**STATE SIGNIFICANT DEVELOPMENT
ASSESSMENT REPORT:
*Faculty of Arts and Social Sciences
Building, The University of Sydney
(SSD 7081)***

Environmental Assessment Report
Section 89H of the *Environmental Planning and
Assessment Act 1979*

December 2016

2 SSDA\_Awning Section 1  
SCALE: 1/188

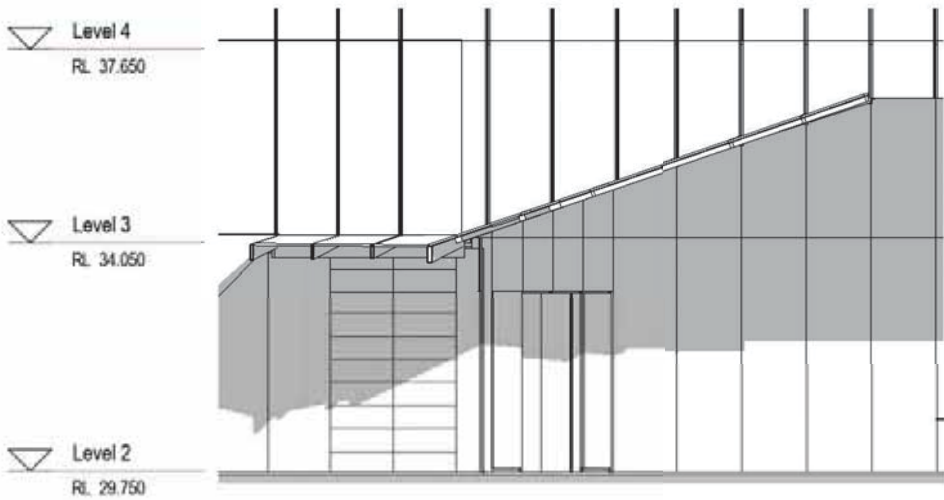
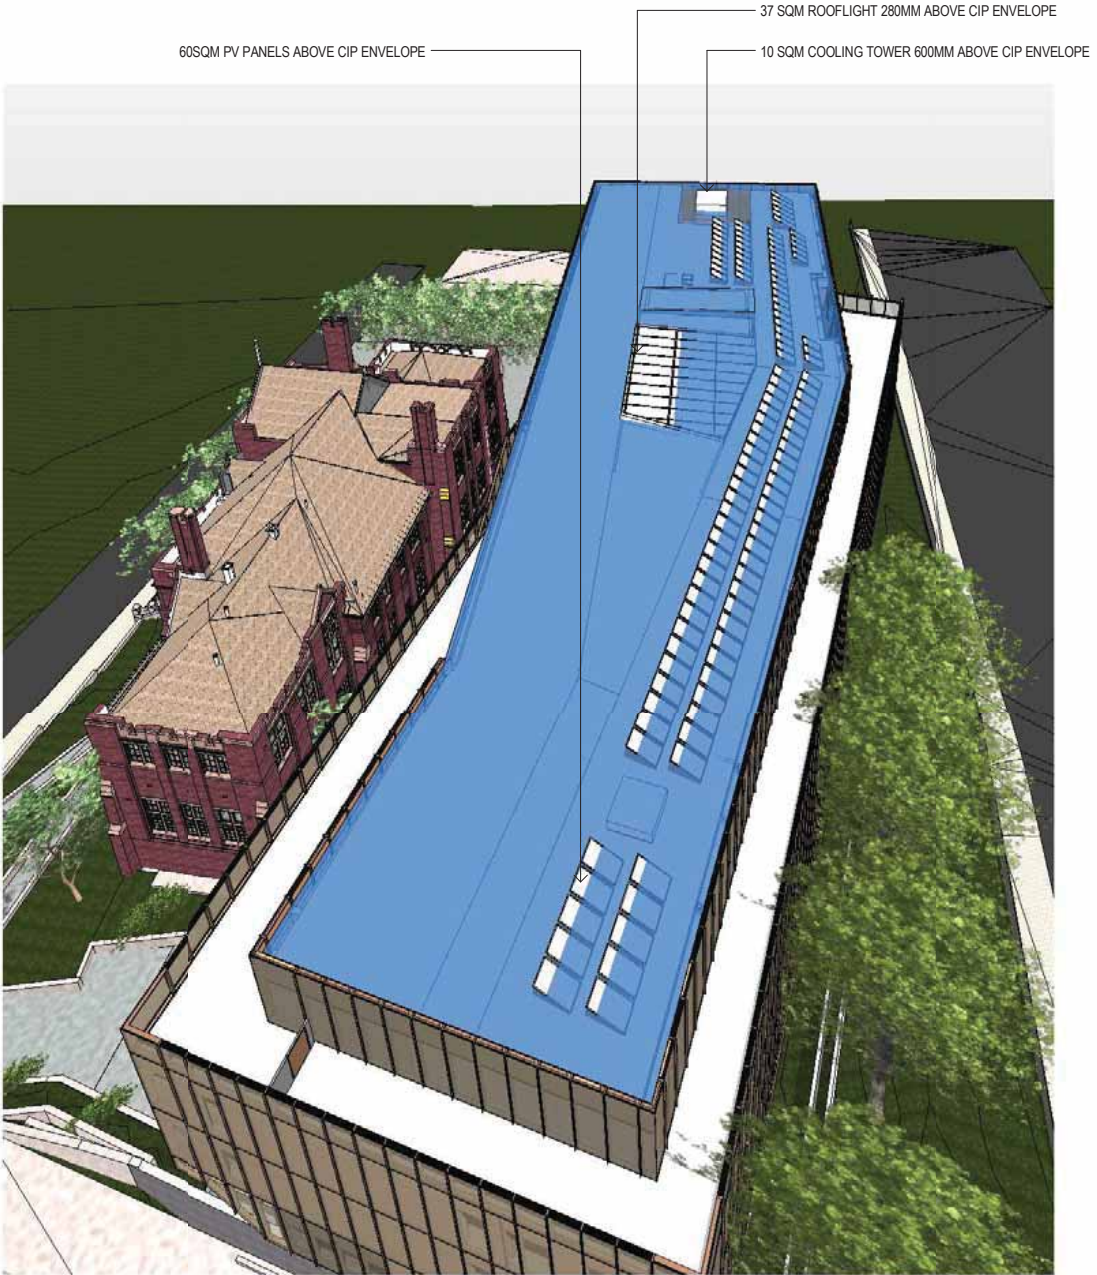
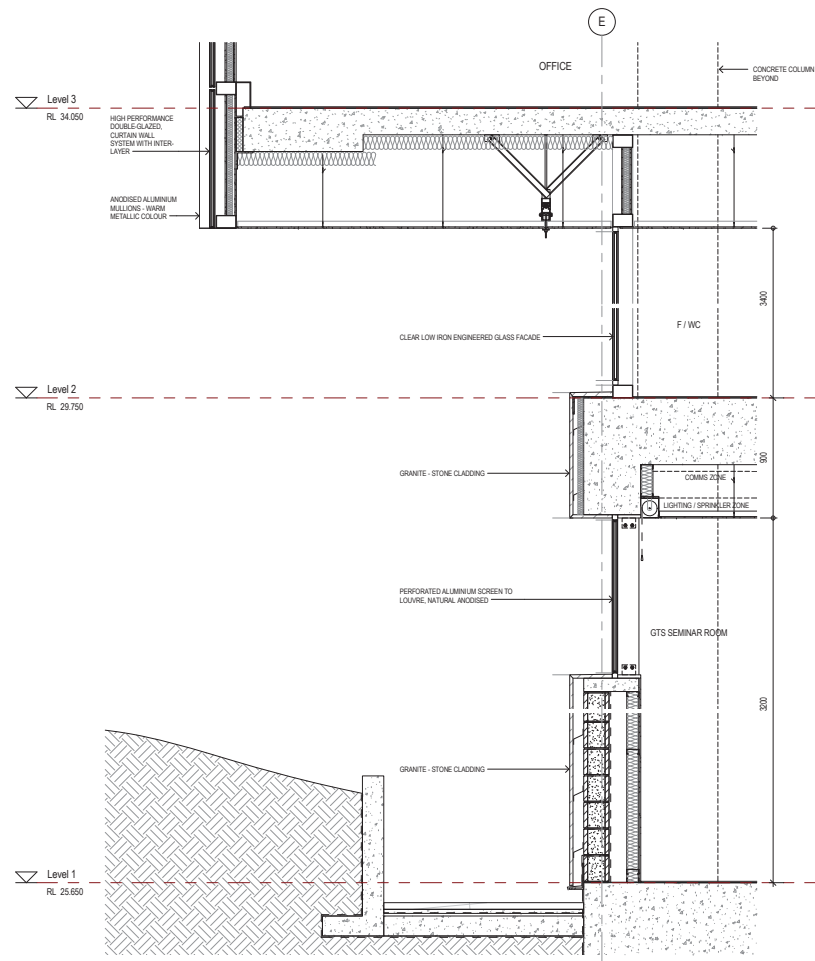
- further detail should be provided on the proposed awning between the FASS building and the existing RD Watt building to ensure that visual and physical impacts on the heritage listed RD Watt building are minimised;
